Subject: Re Planning Application EP/67/20/PL 47 The Ridings, East Preston.

47 The Ridings, East Preston

We wish to make the following objections/negative comments re the above Planning Application.

DRAWING TITLE
PROPOSED FLOOR PLANS, ROOF PLAN &
ELEVATIONS

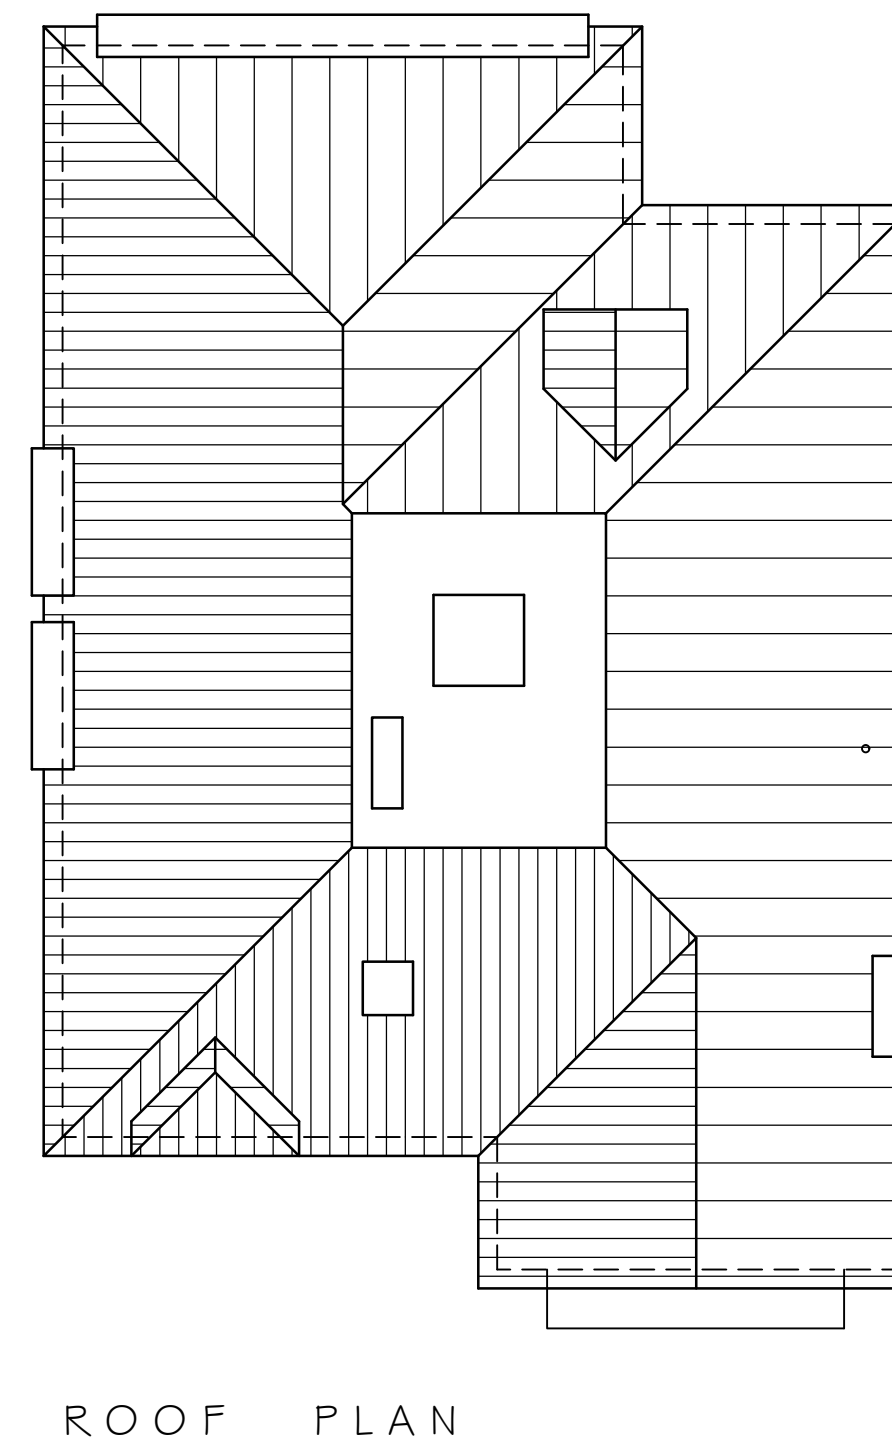
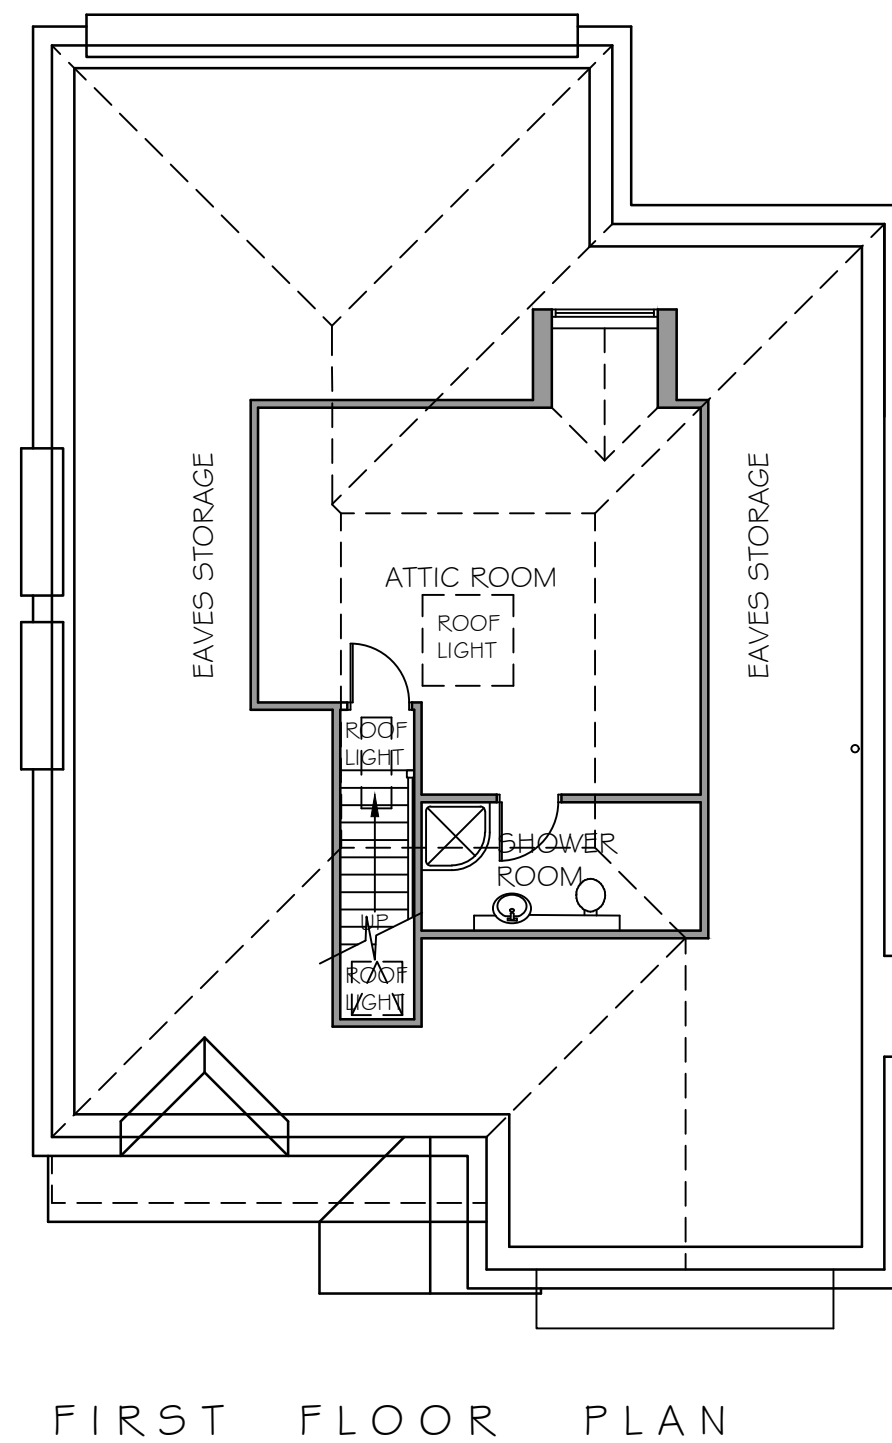
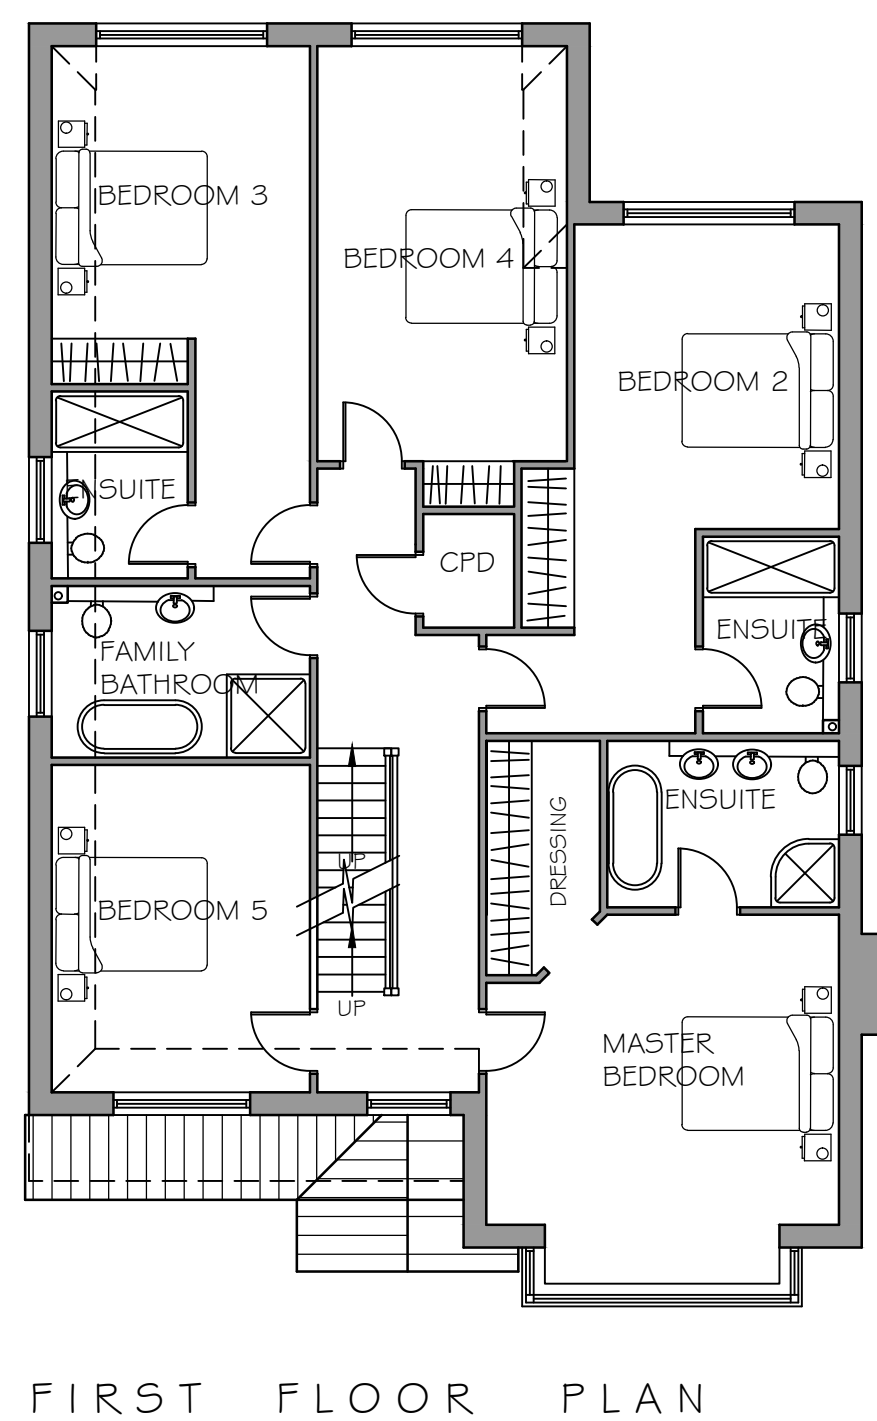
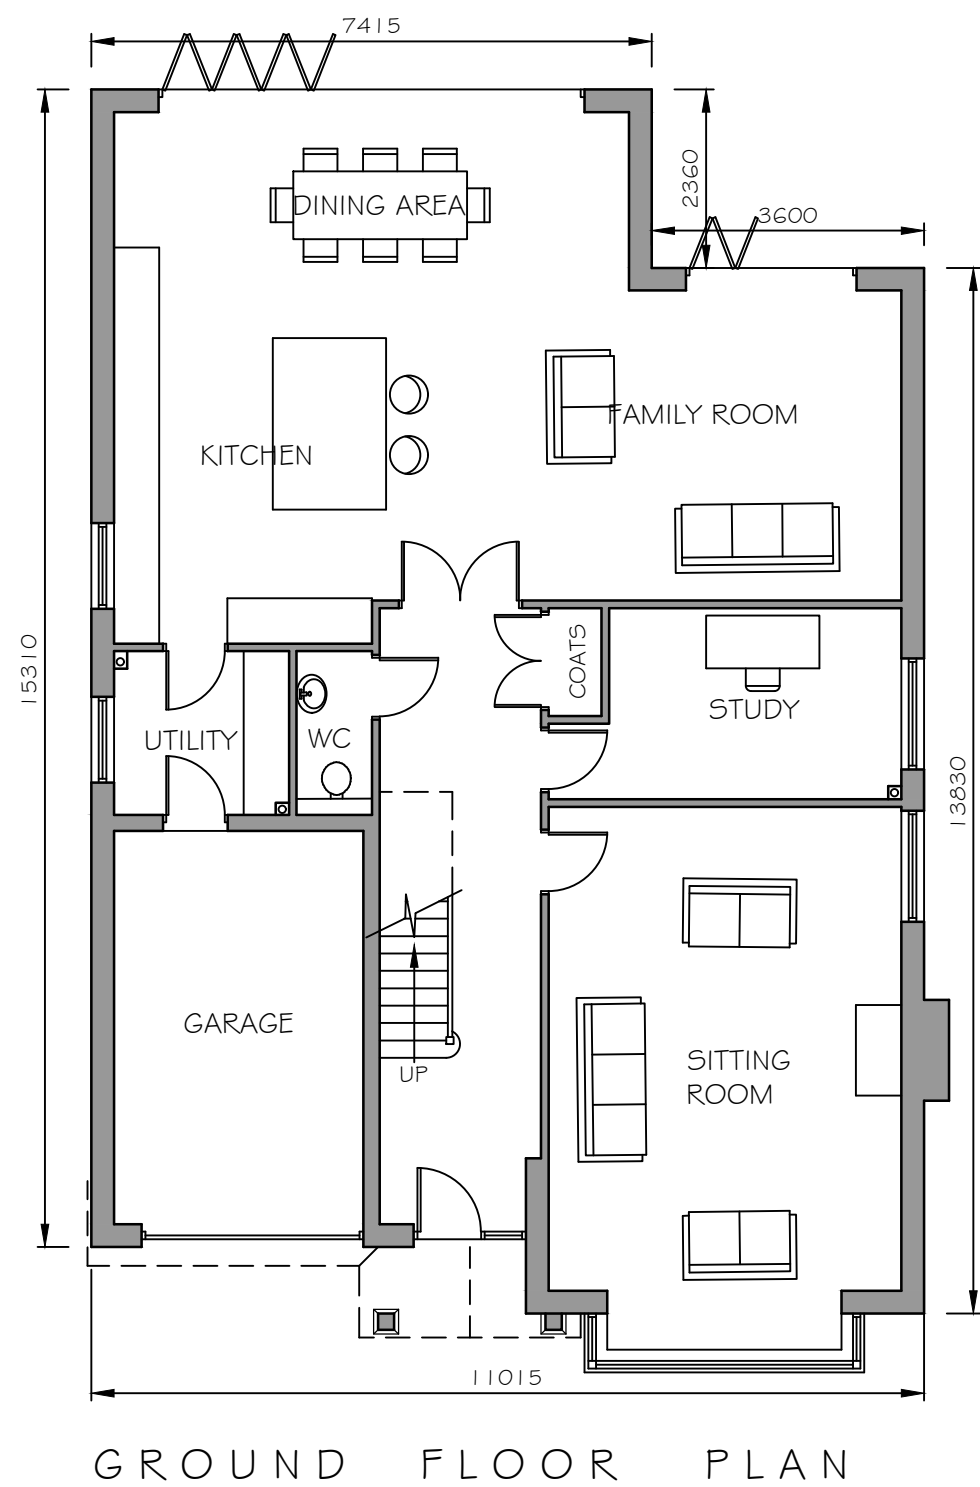
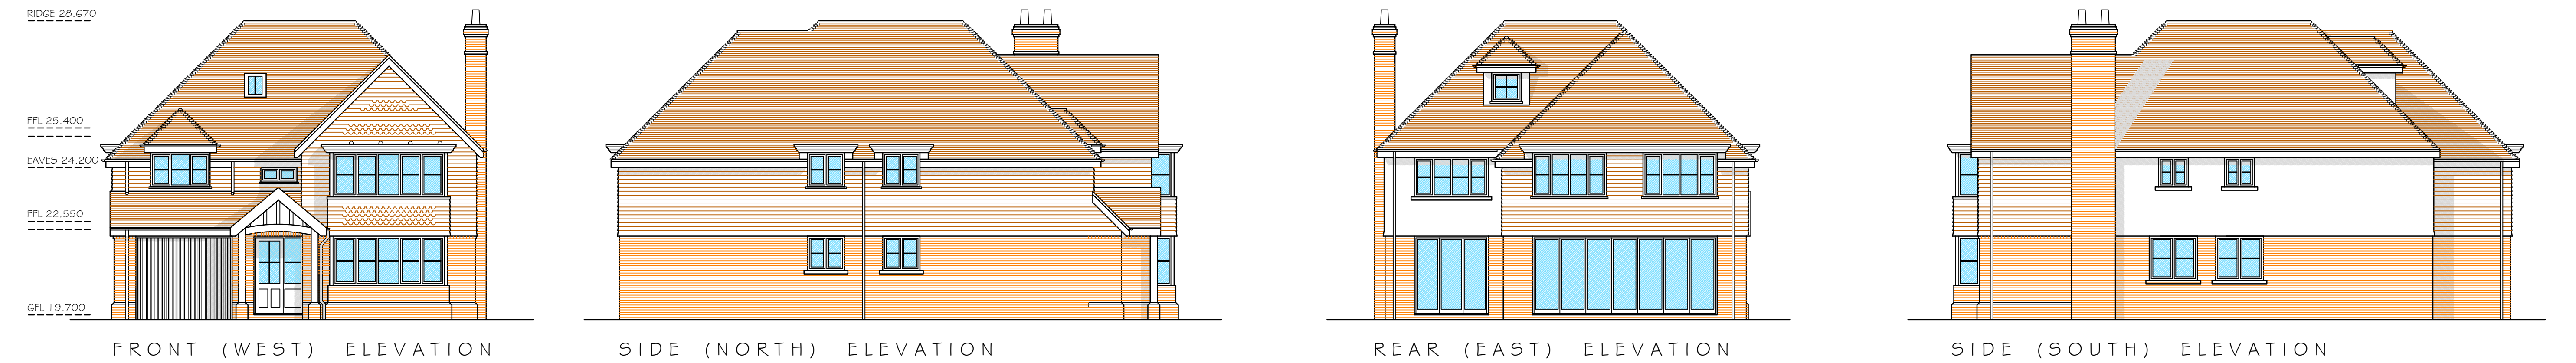
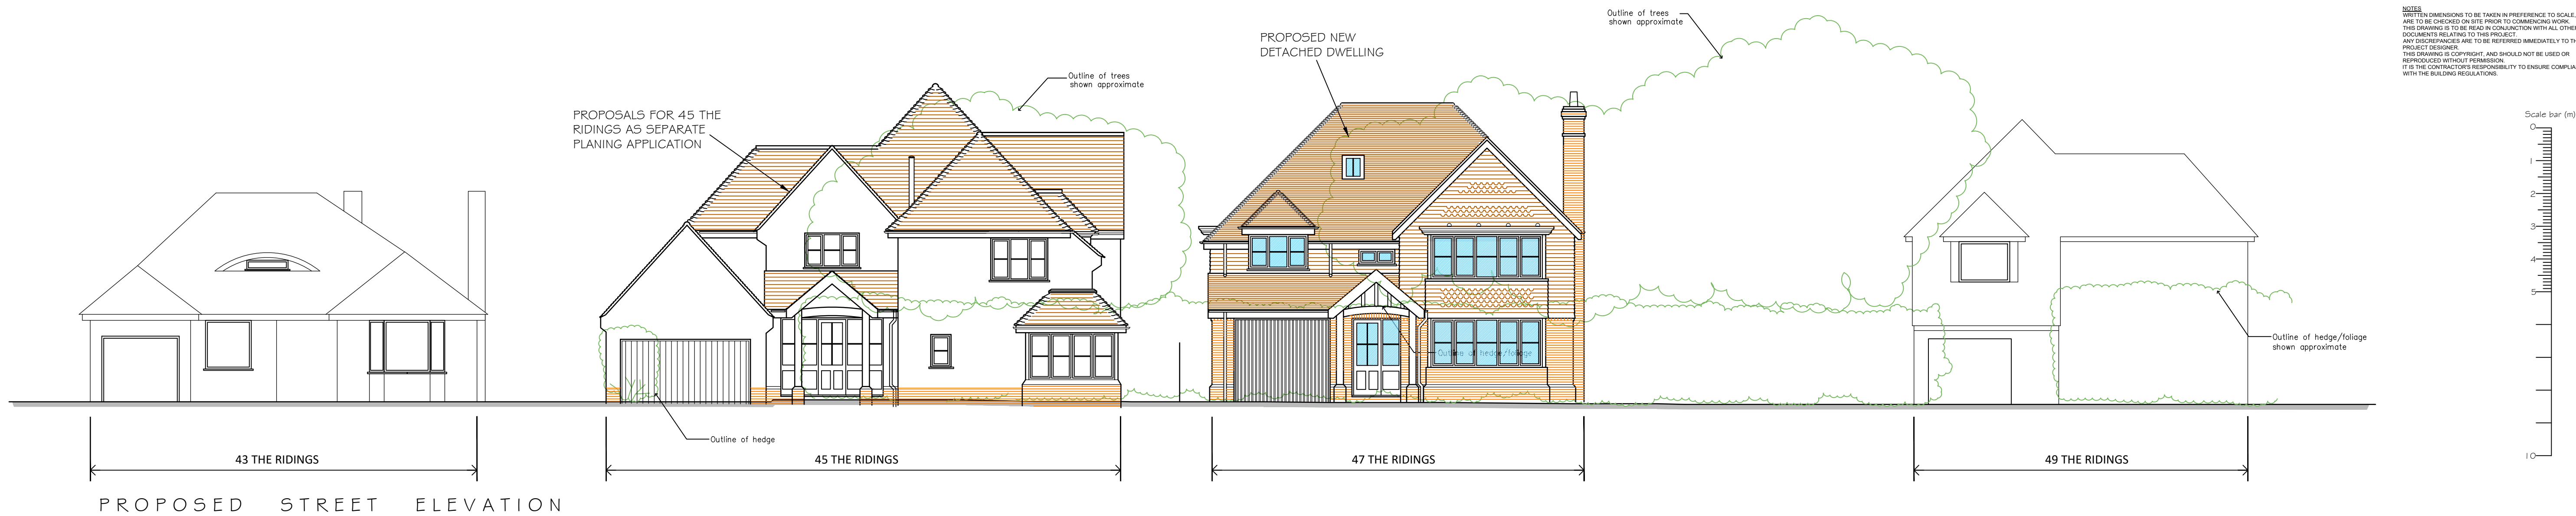
There are 6 bedrooms shown on the plans, but only a single car garage. The driveway is quite short, not very wide with a small turning(?) area. Where will the vehicles that one expects to belong to the inhabitants of a 6 bedroomed house park? Also the vehicles belonging to any visitors to the property? The Willowhayne Estate policy is that parking is not permitted on estate roads.

There is no reference as to the actual height of the proposed dwelling. Living accommodation is shown as being on 3 floors and thus it is likely that the dwelling will be higher than those immediately surrounding it which is not an acceptable situation. Planning permission has in recent weeks been granted for another large house in the same plot of land (No.45). The 2nd of two large 6 bedroomed houses in the same plot, culminating obviously in two much smaller plots. These two houses within The Ridings will fall within the East Preston Village Design Statement which comments that 'any new development should not clash with its surroundings, and that the relatively large gardens should be retained as they are a characteristic of the area'. We would argue that looking at those properties surrounding the proposed development that this Application does not conform.
